Please ask for: Sian Eggington
Email: sian.eggington@terraquest.co.uk
Telephone: 0121 2341390
Our Ref: AB/105/20/HH
Your Ref:
Date: 1st October 2020

Application for Planning Permission for Works or Extension to a Dwelling

Development: Construction of a greenhouse in the rear garden
Location: 36 King Street Arundel BN18 9BW

**UK
Planning
Maps**

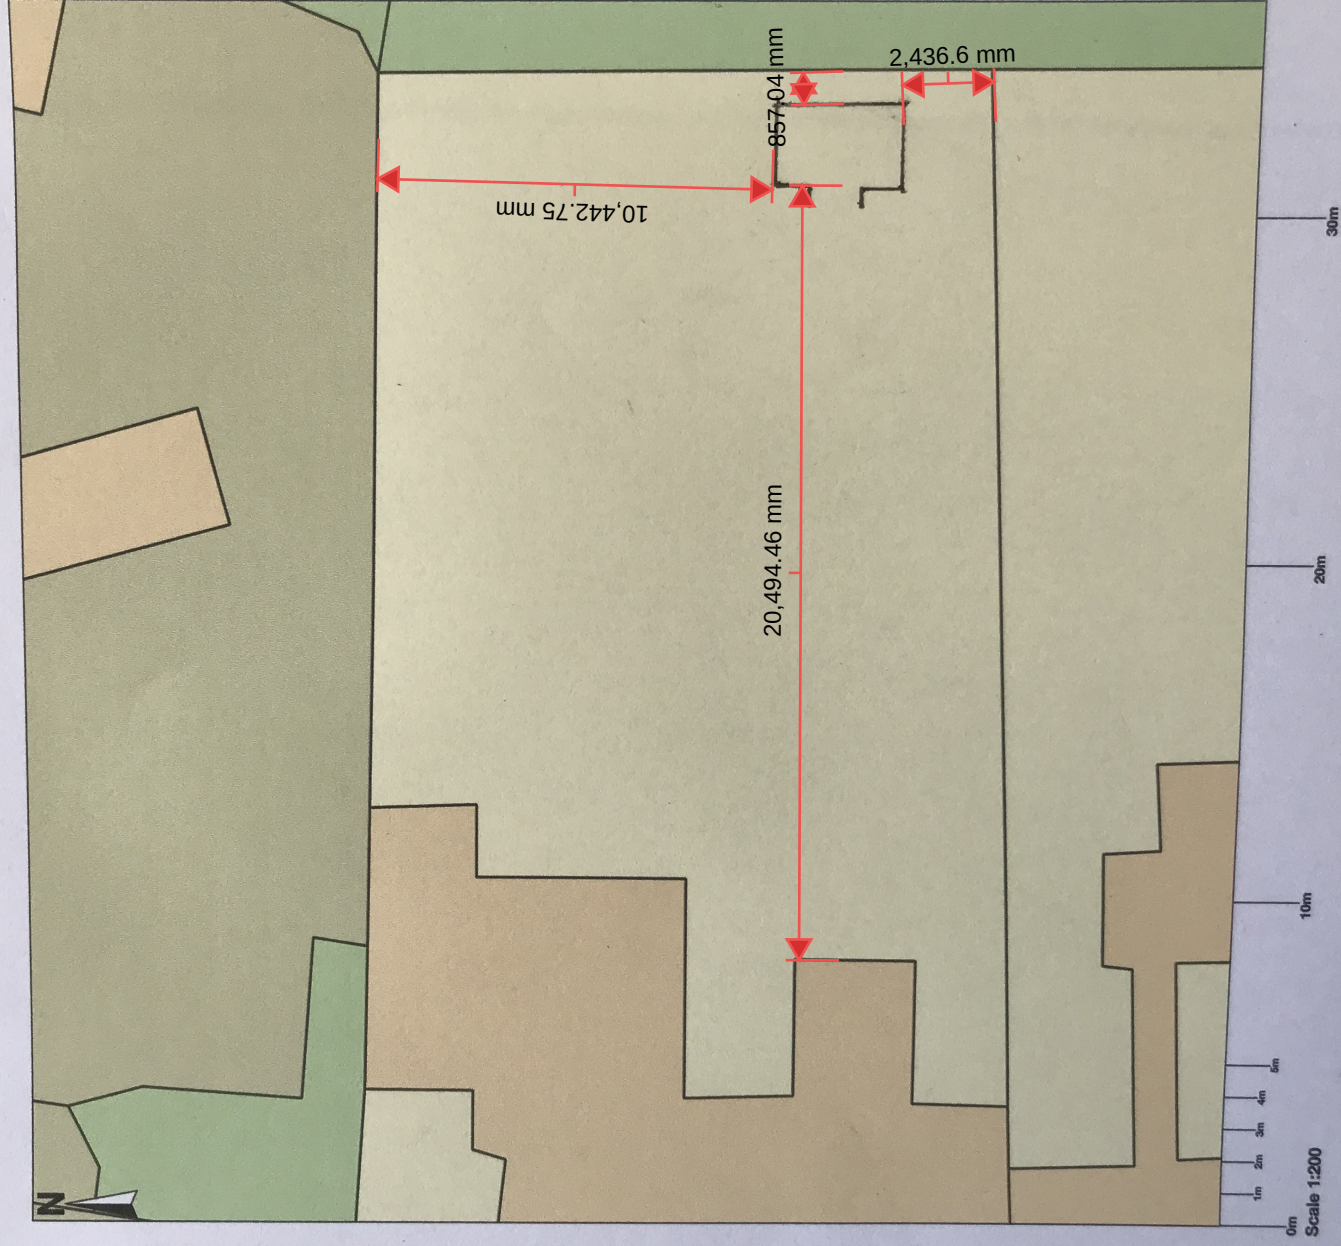
Block Plan: You are required to include dimensions on the block plan from the propose greenhouse to all site boundaries.
